KITITAS COUNTY

MEMORANDUM

TO: Community Development Services
FROM: Public Works Planning Review Team
DATE: February 1, 2021
SUBJECT: BL-21-00002 Kypreos-Collins

RECORD OF SURVEY
 A PTN OF THE NE 1/4 OF THE NW 1/4 OF SECTION 12,
 TOWNSHIP 20 NORTH, RANGE 14 EAST, W.M.,
 KITTITAS COUNTY, WASHINGTON

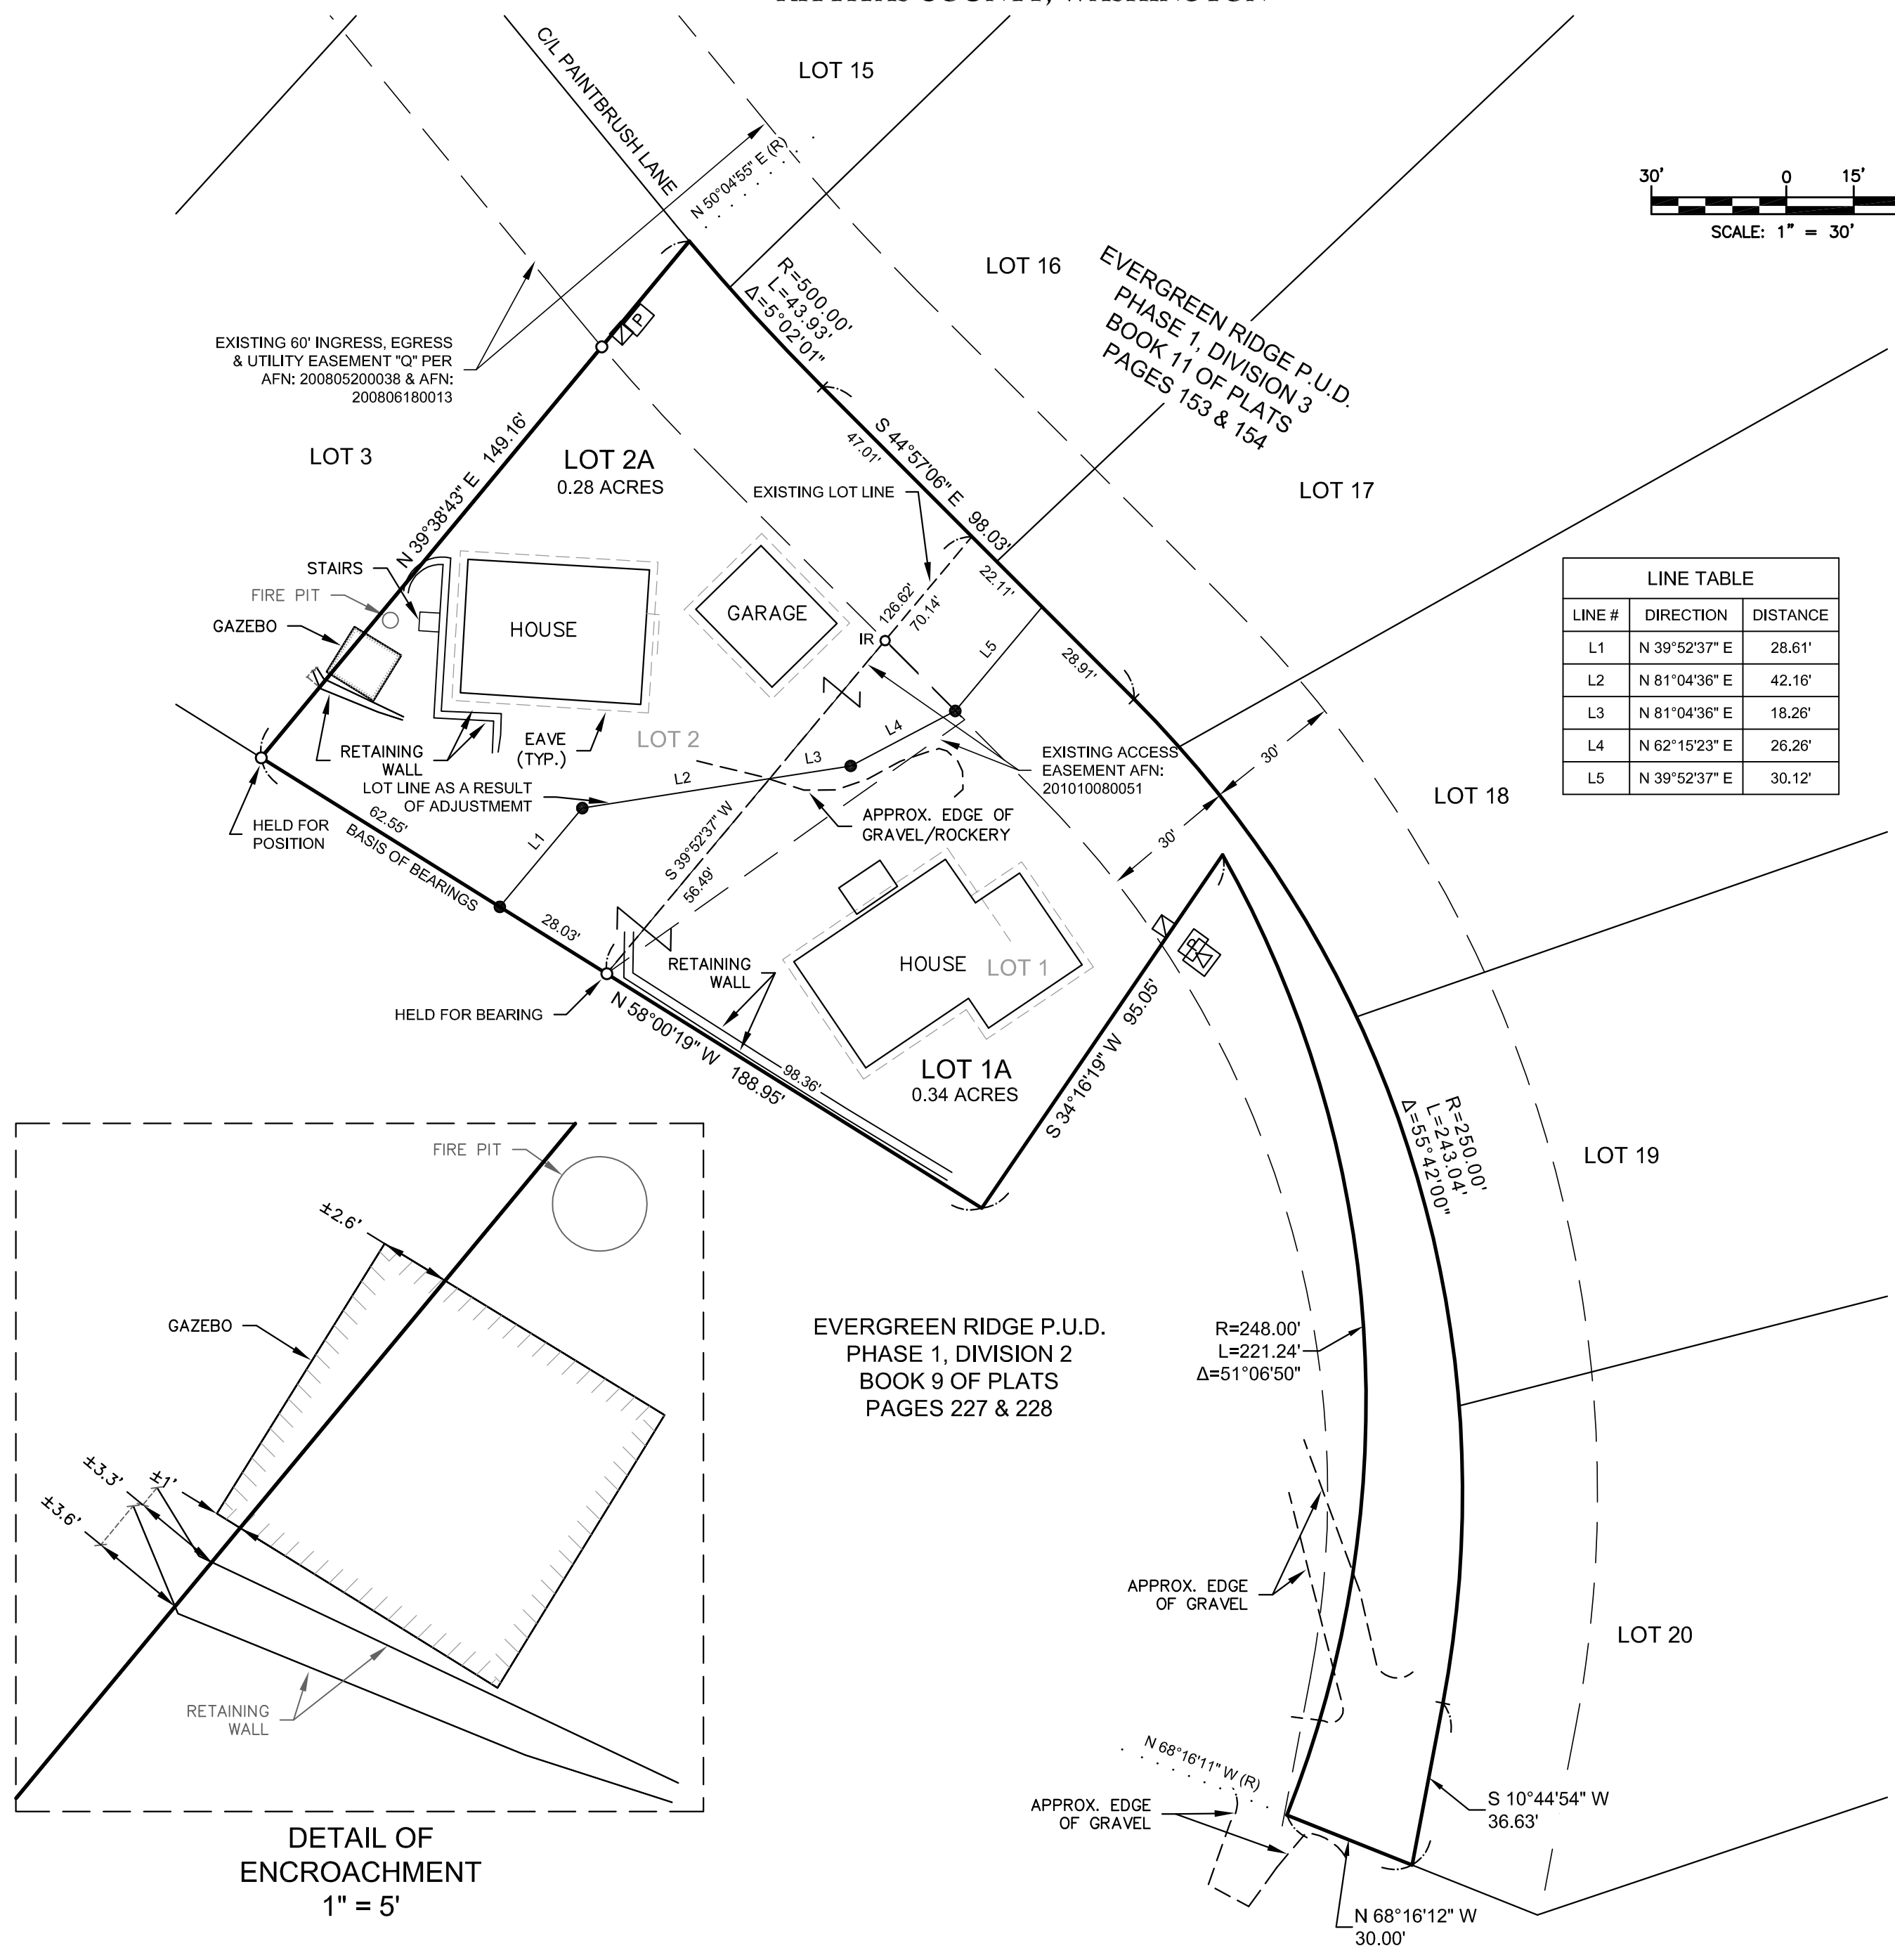
While the provided map is clearly Preliminary in nature, I feel it is good enough to comment for final submittal requirements. The subsequent comments reflect final approval, not preliminary.

1. Basis of bearing to be addressed
2. Survey Methods and procedures statement to be included
3. Purpose of survey statement to be included
4. Surveyor's and Auditor's Certificates to be included
5. The south line of Lot 1A dimension is obscured by topographic features
6. Encroachments and trespasses should be noted with dimensions to nearest lot lines
7. Survey Corners should be set on the new division line.
